From: Scott Steffen <ssteffen@bhinc.com>
Sent: Wednesday, August 27, 2014 11:42 AM
To: Cherne, Curtis
Cc: Rick Beltramo; Ortiz, Monica
Subject: Trails Unit 3a DMP ponds
Attachments: Trails Unit 3A DMP ponds Grading Plan.pdf

CITY OF ALBUQUERQUE	
		PUBLIC WORKS DEPARTMENT	
TRAILS UNIT 3A DMP PONDS			
POND D1			
GRADING PLAN			
Design Review Committee	City Engineer Approval	Mo./Day/Yr.	Mo./Day/Yr.
City Project No.	Zone Map No.	Sheet	Of
XXXXXX	C-09-Z	2	5

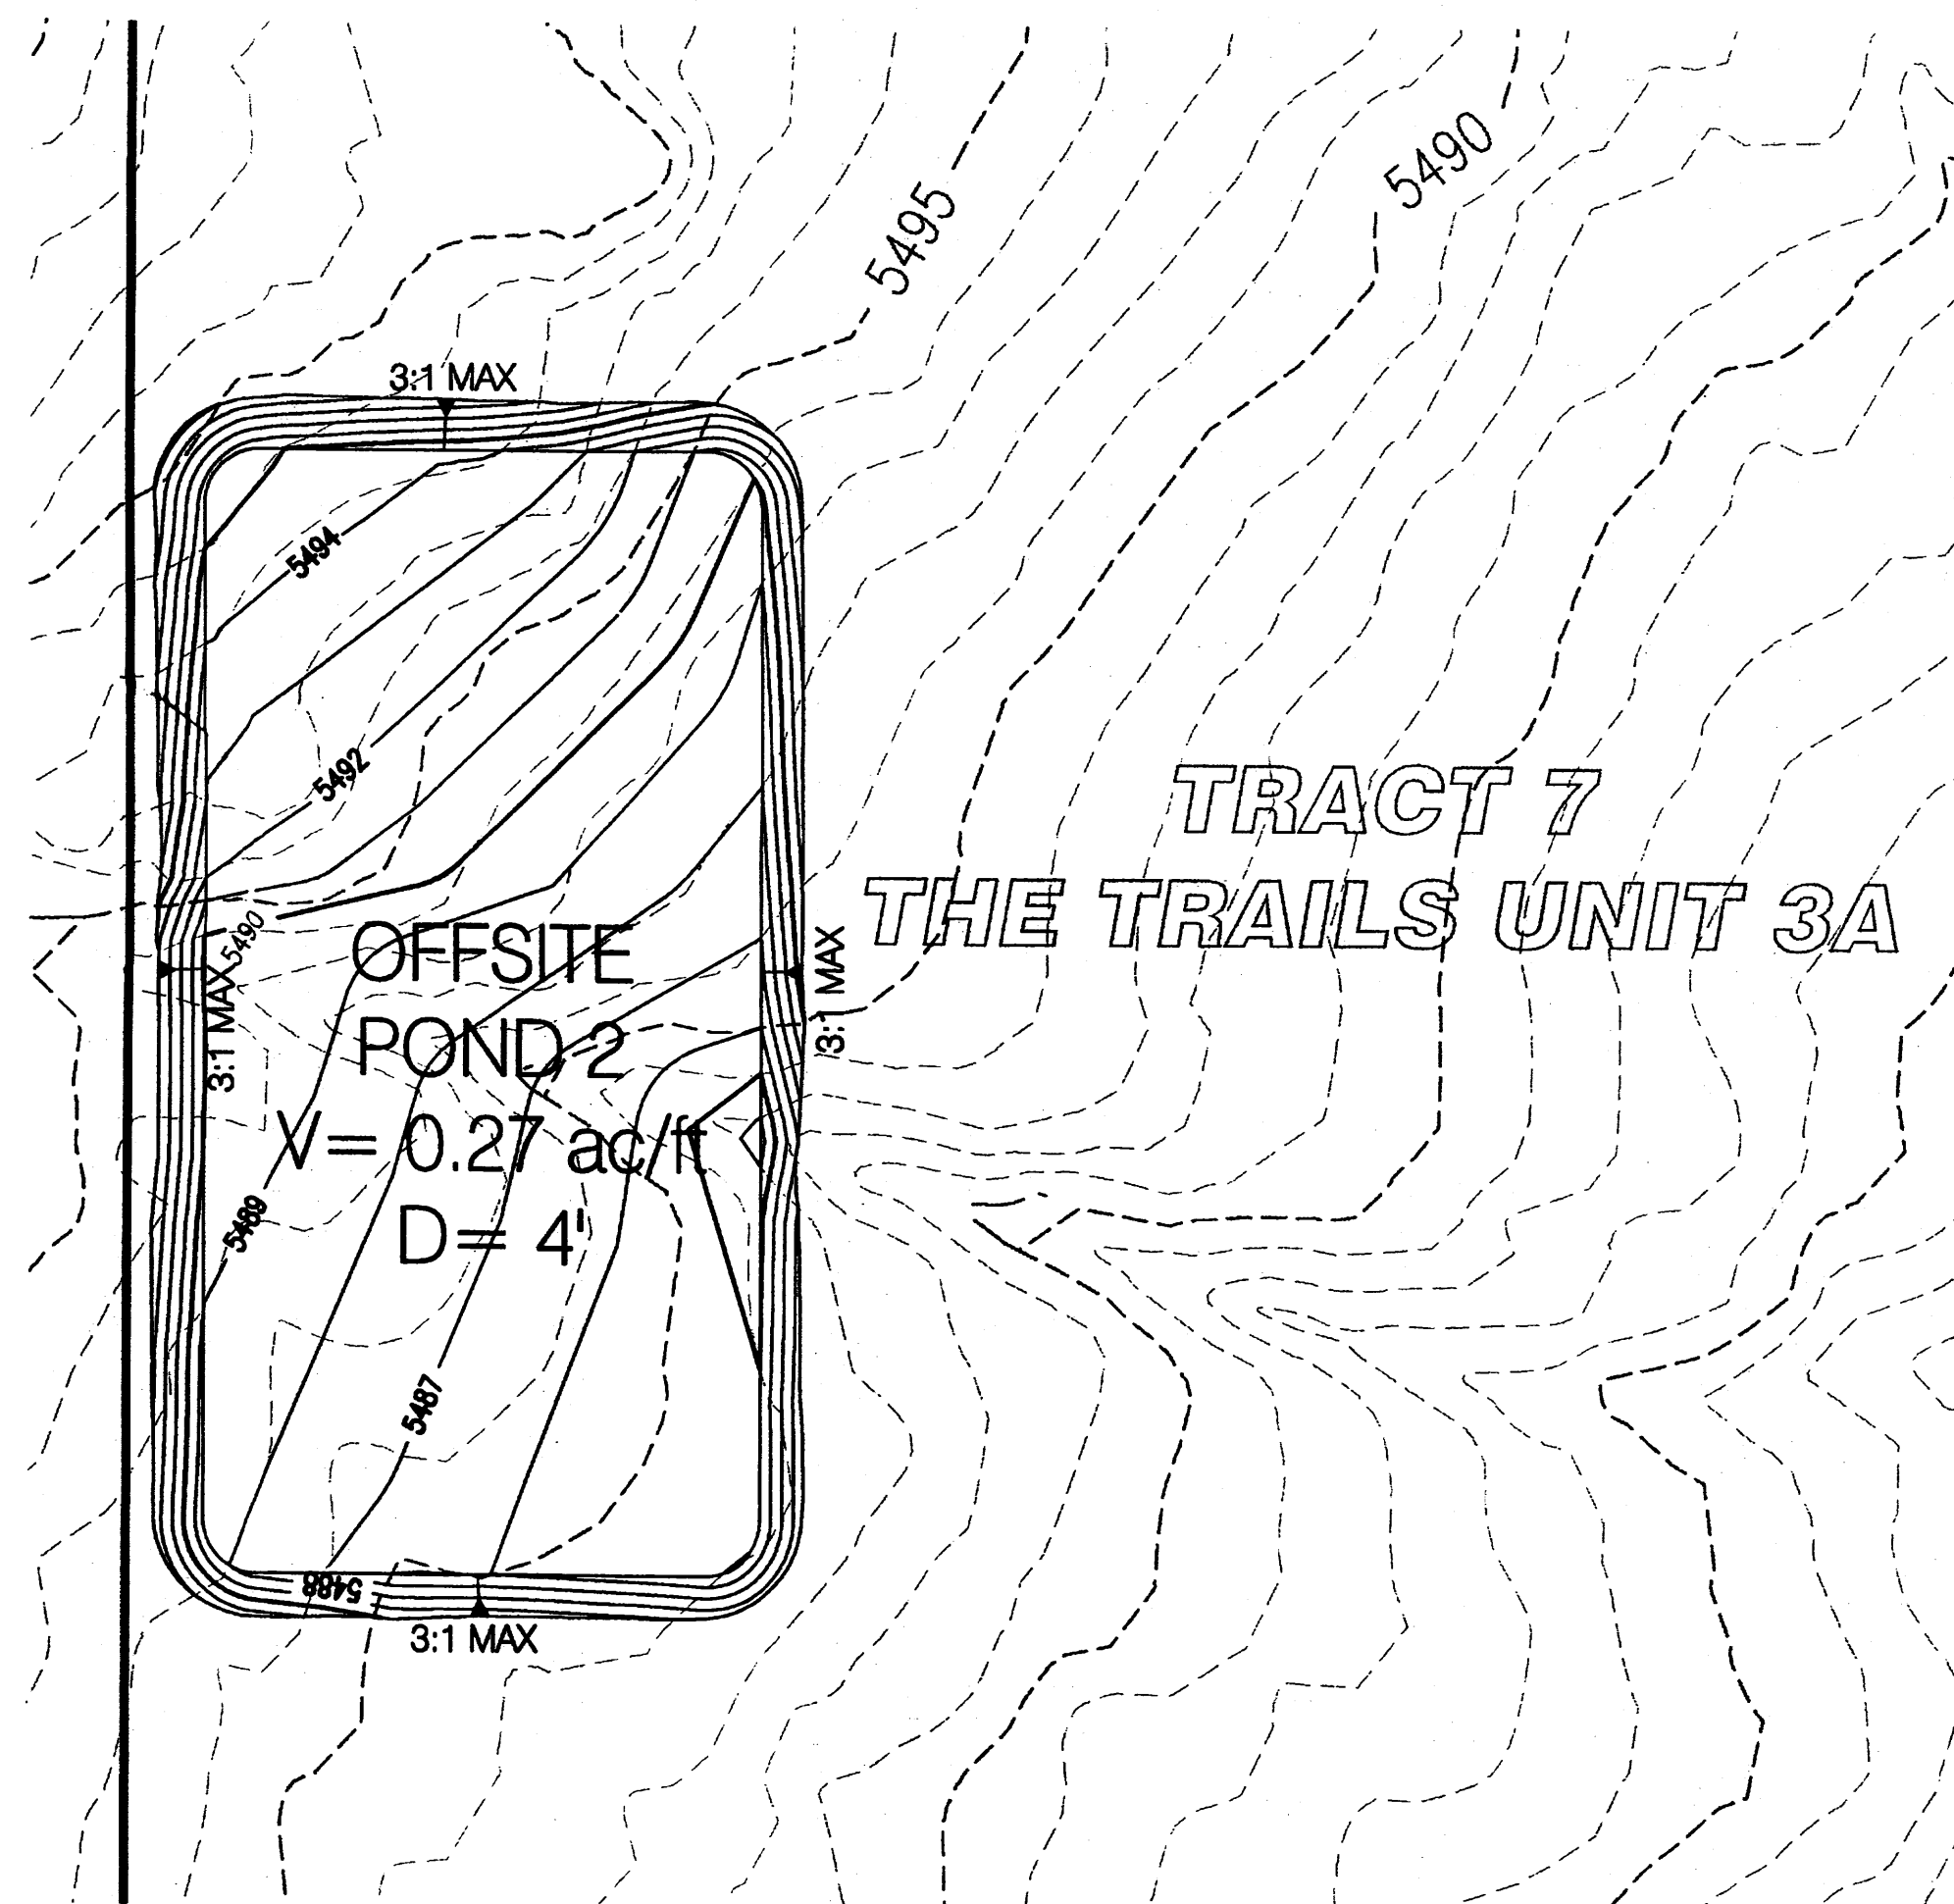
Attached is the grading plan for the Trails Unit 3a DMP ponds. We have added proposed haul routes from the ponds to the Valle Prado subdivision and the Heritage storm drain pipe at Pond D1. Pond D-1 on Tract 5, west of the Heritage Subdivision shows a proposed CMP standpipe, which connects to the existing 30" storm drain in Heritage. We have not provided details of the standpipe at this time. We request that you review/comment/approve the grading plan without a detailed design of the standpipe. Once grading of the pond is complete and we get as-built information on the existing storm drain and pond we will prepare a design of the standpipe so that it functions per the as-built conditions.
